RE: Modification request for Star City Casino and Switching Station – Modification 14 (MP 08_0098 MOD 14)

Katrina Stankowski
Acting Manager, Conservation
Heritage Division
Office of Environment & Heritage
As Delegate of the NSW Heritage Council

BUILDING ELEVATIONS - SHEET 2

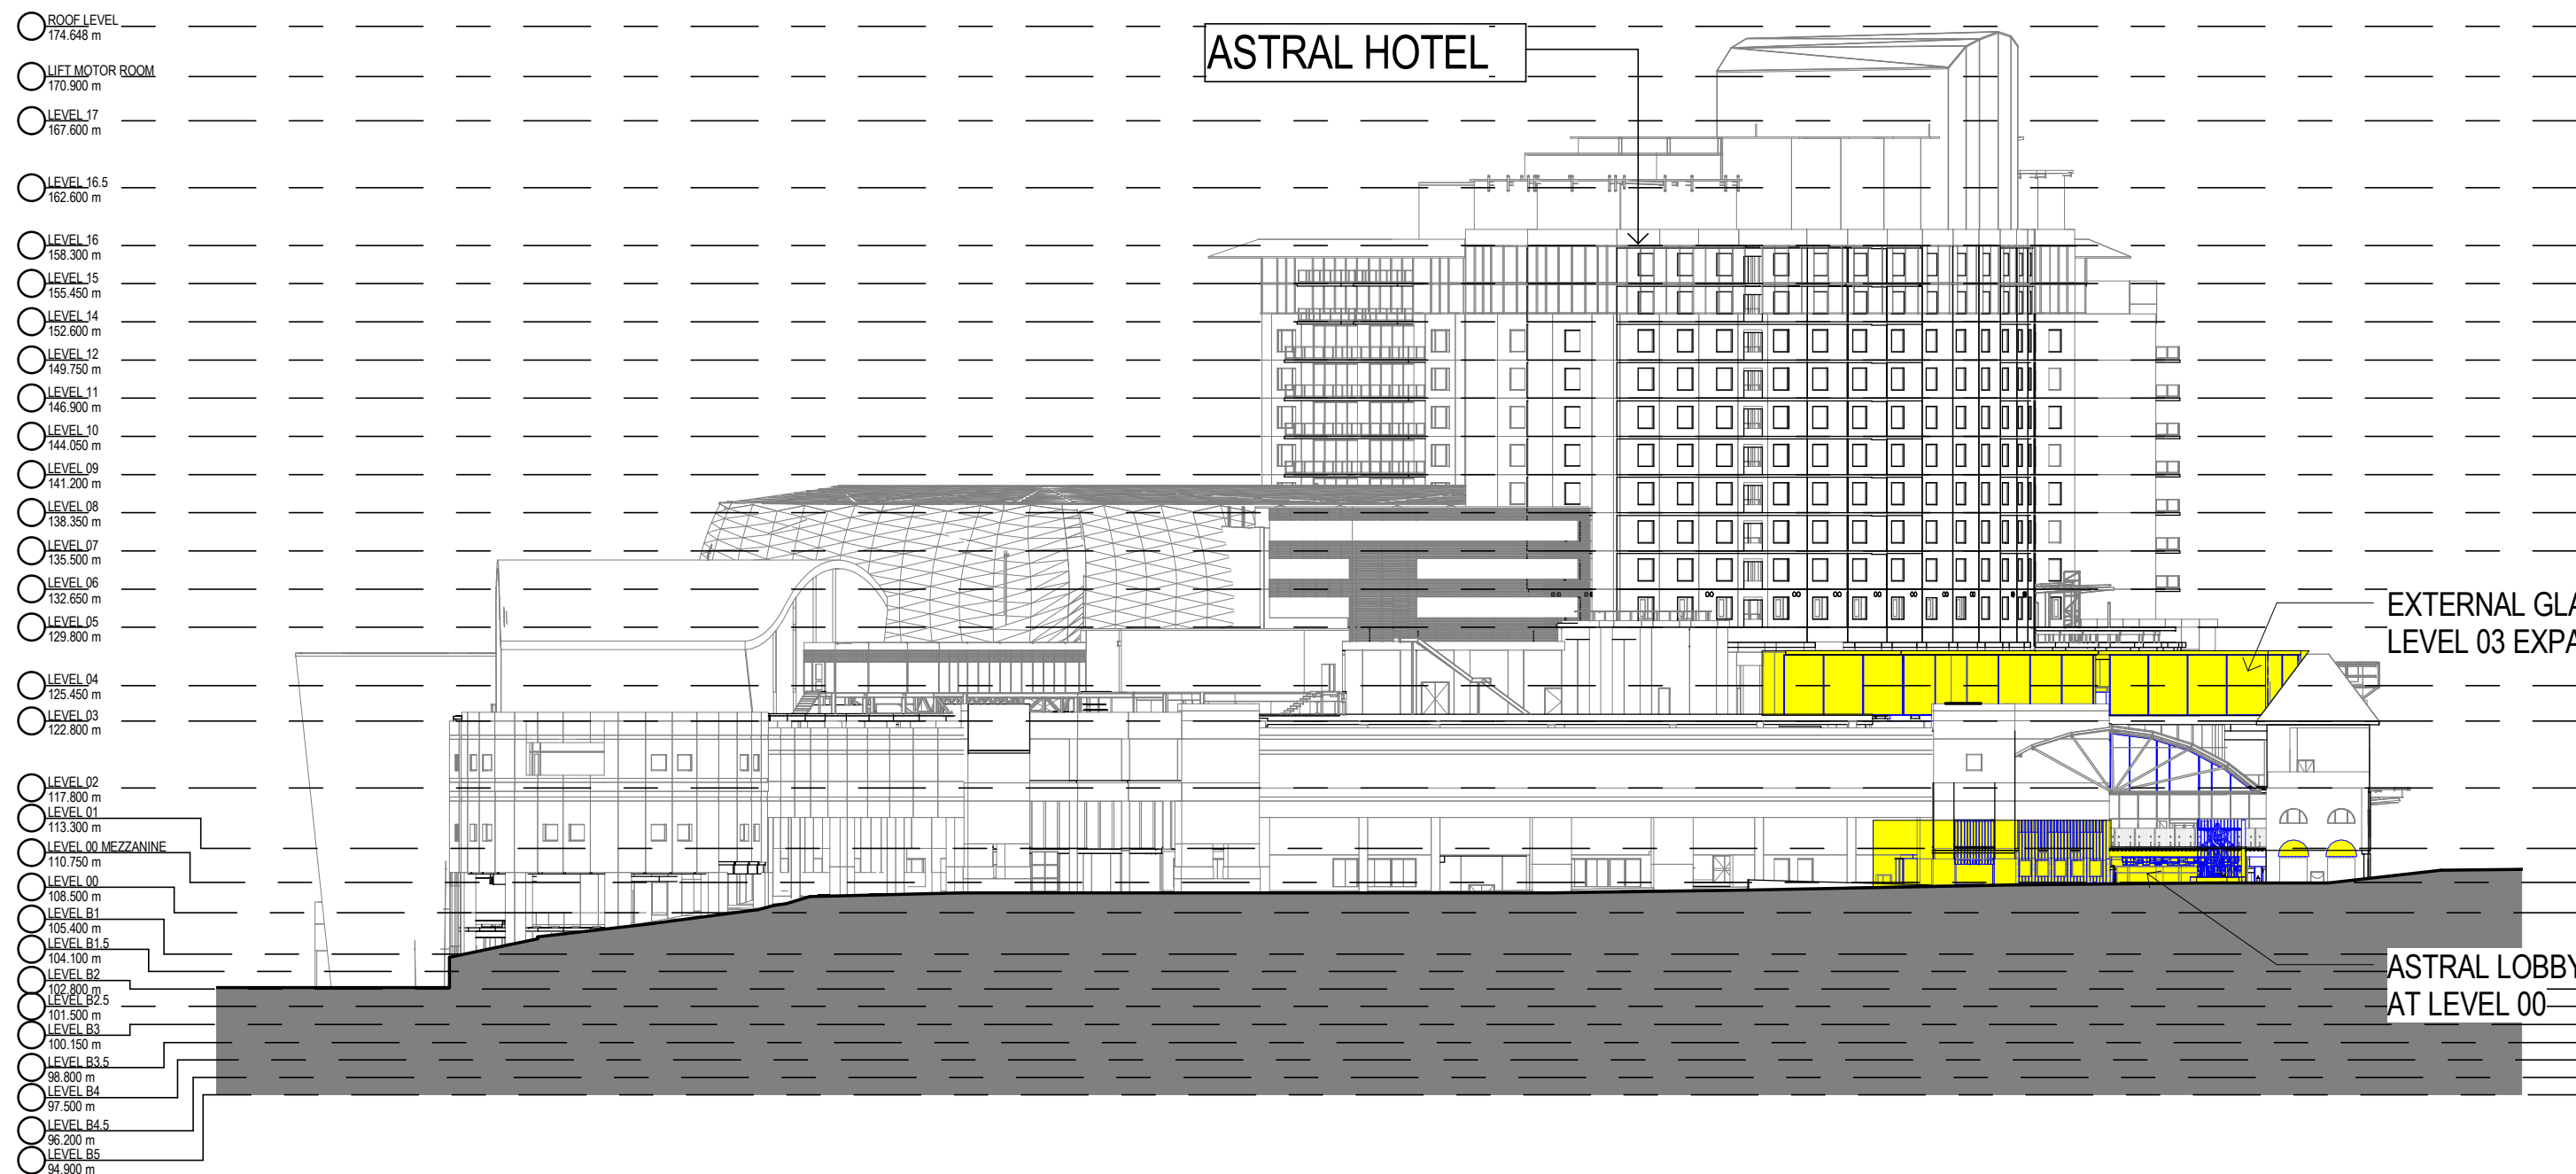
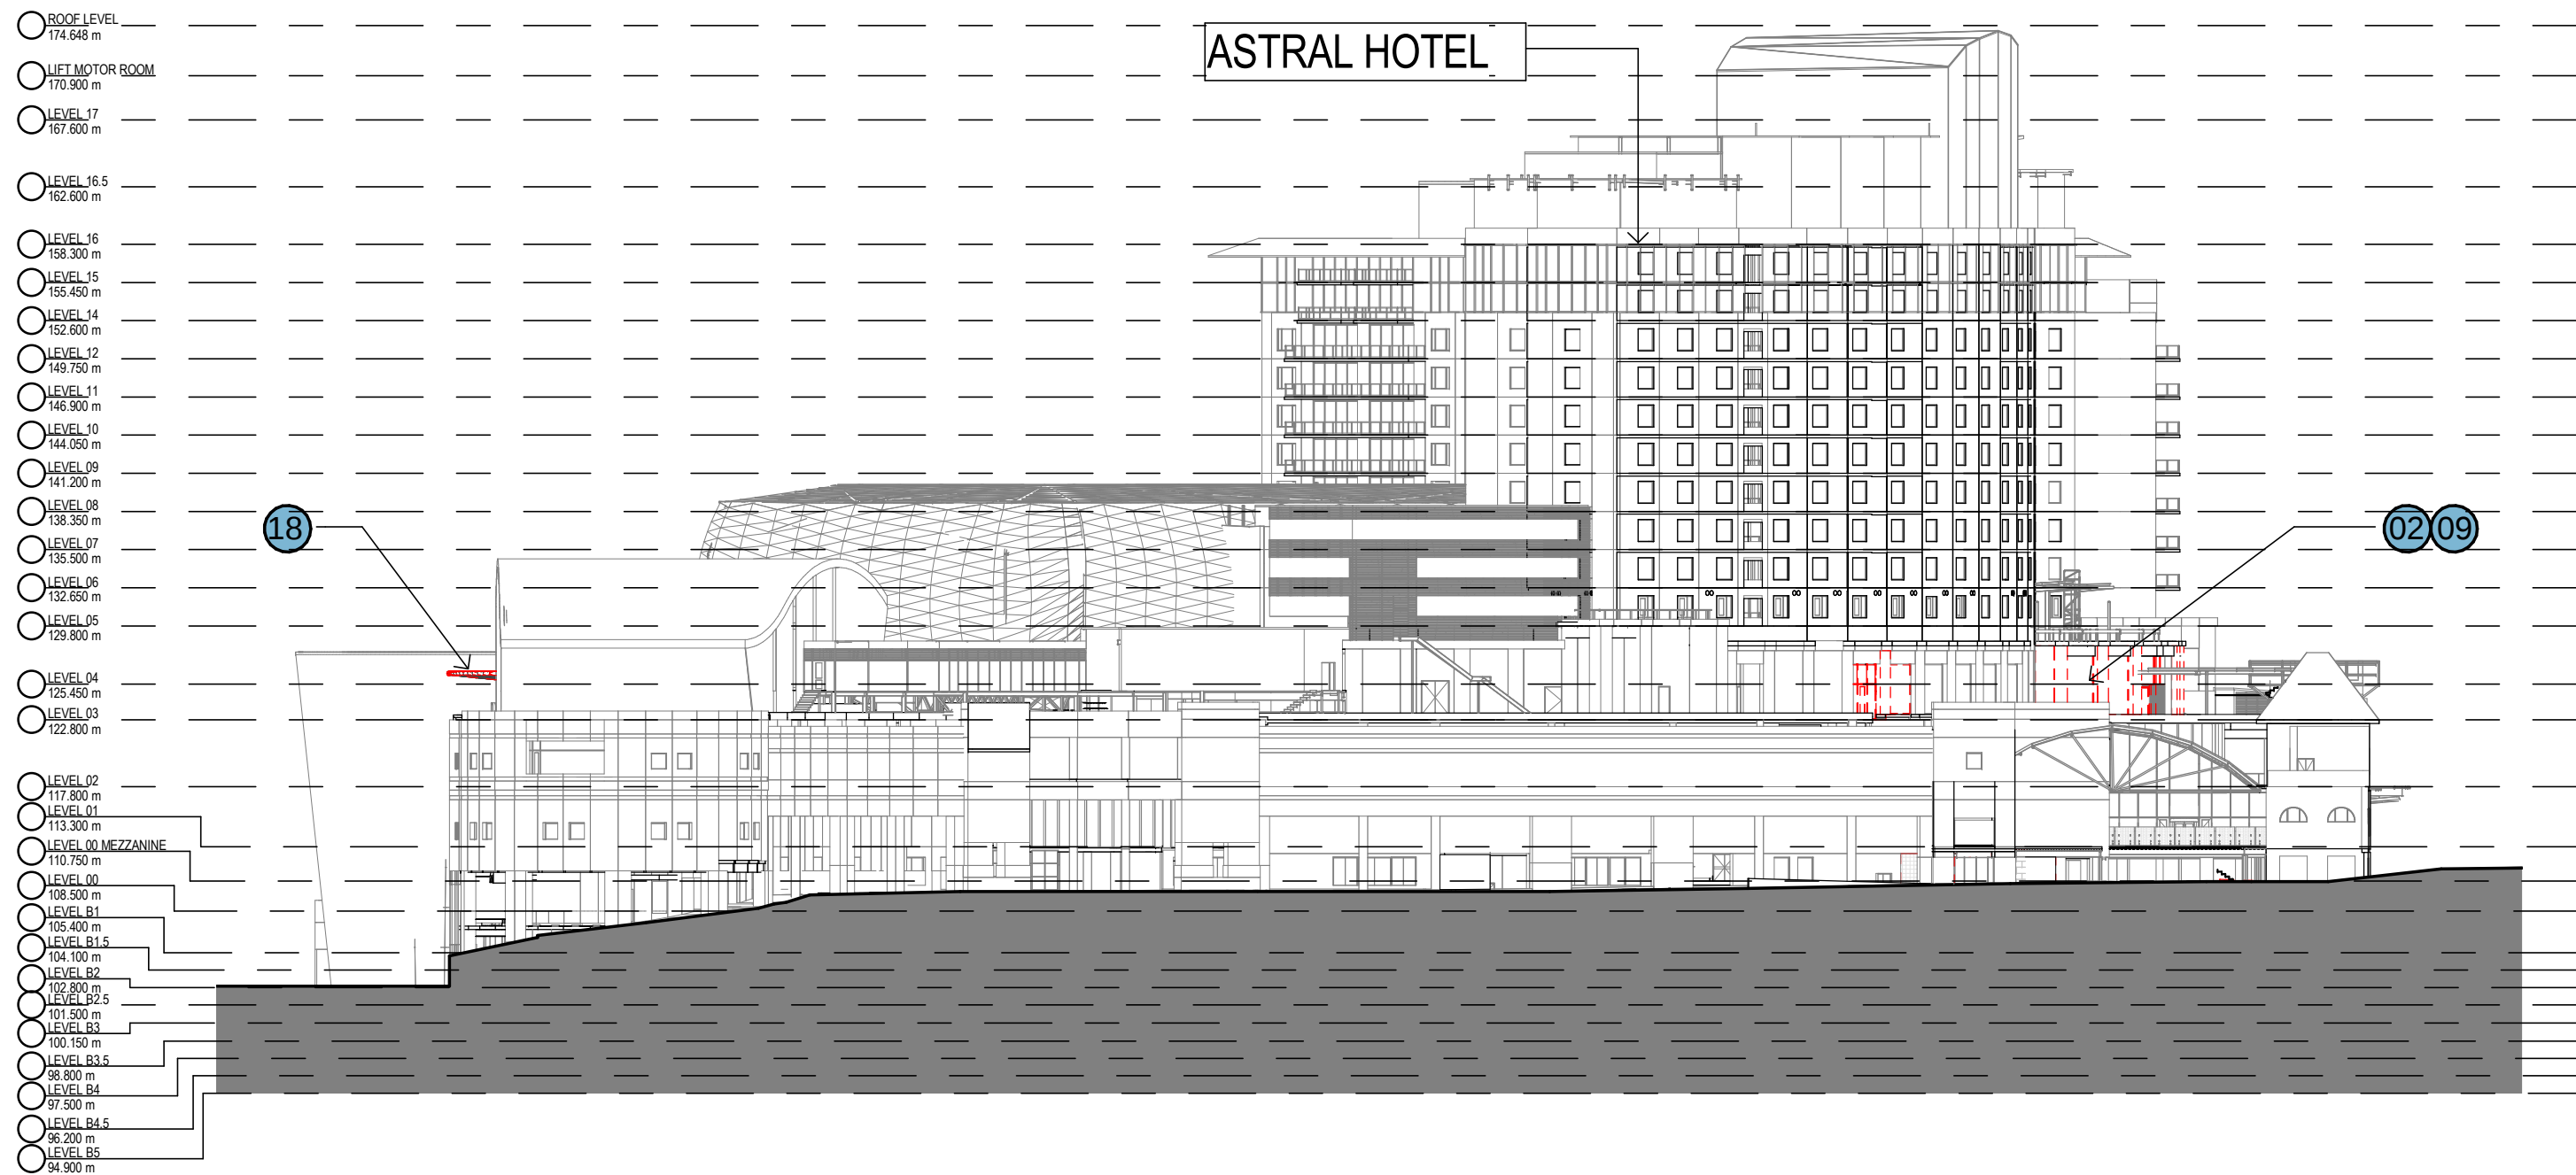
Upgrades and tenancy improvements to the northern end of the SELS building, which includes replacement of existing canopies along Jones Bay Road, should be carried out in a way that the integrity of the façade is not compromised. Careful consideration should be given to the recommendations made in the Heritage Impact Statement report, by URBIS Pty Ltd.
